Planning Application – Anglian Water Response

Site: Former Bull And Monkie Church Gate
Spalding PE11 2RA

Proposal: Demolition of vacant former public house
and erection of 88 bed care home including
onsite parking amenity space and
associated works.

Planning application: H16-0767-23

Drawing Title:
EXISTING FOUL & SURFACE WATER DRAINAGE
ROUTE BEYOND EXTENT OF SITE BOUNDARY

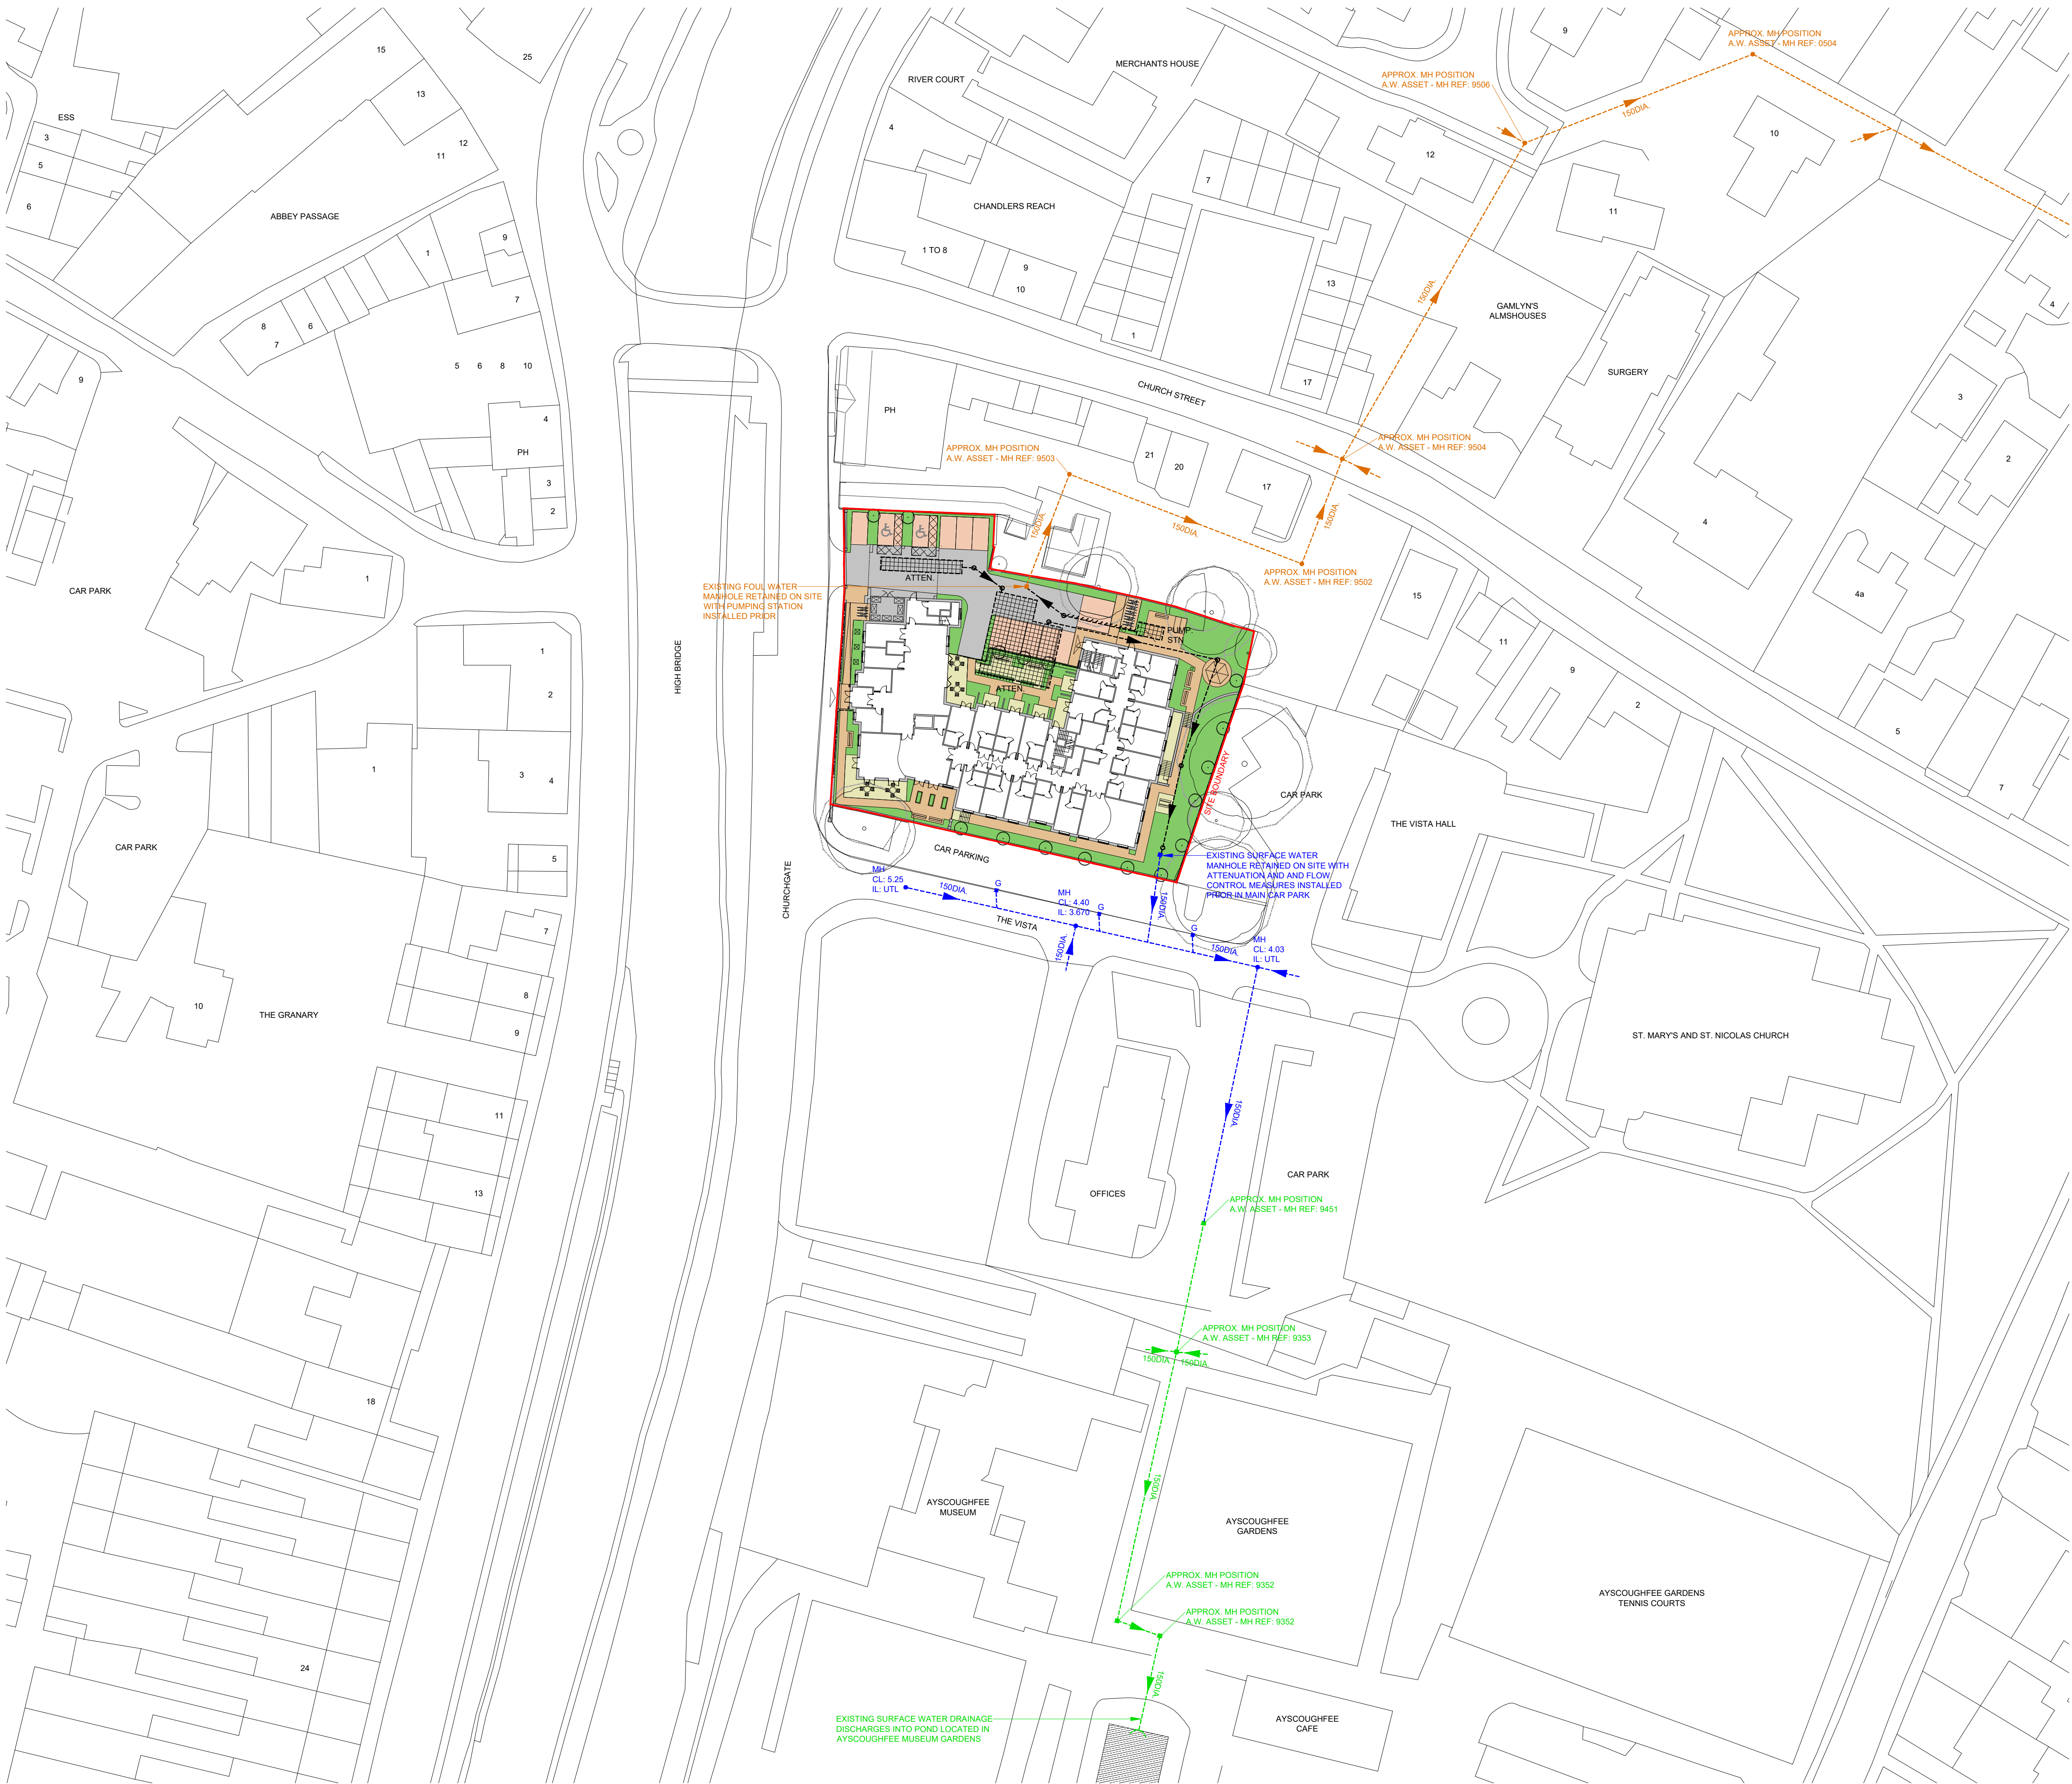
We have reviewed the submitted 221/1811/SK02 Site Drainage Plan, 221/1811/SK01 Existing Foul & Surface Water Drainage Route Beyond Extent of Site Boundary, FRA & SUDS-Former Bull & Monkie PH Spalding Rev C Flood Risk Assessment & Surface Water Drainage Strategy- June 2023. There is insufficient evidence of the existing connection to demonstrate the assumed existing surface water connection into the Anglian Water network. The submitted infiltration testing is also insufficient. In accordance with BRE 365 , we would expect to see the infiltration testing for a minimum of 24 hours.

The applicant proposes a discharge rate of 7l/s or 5l/s into a 150mm surface water sewer, the proposed discharge rate is considered to be excessive for this development site and the local surface water network does not have the capacity to accommodate the proposed discharge rate as it will increase the risk of flooding within our network.

To overcome our objection the applicant is required to consult Anglian Water Direct in a form of a Surface Water Pre-Planning Enquiry (PPE) submission. To submit a surface water pre-planning enquiry the applicant can click: <https://www.anglianwater.co.uk/developing/planning--capacity/how-to-apply/>
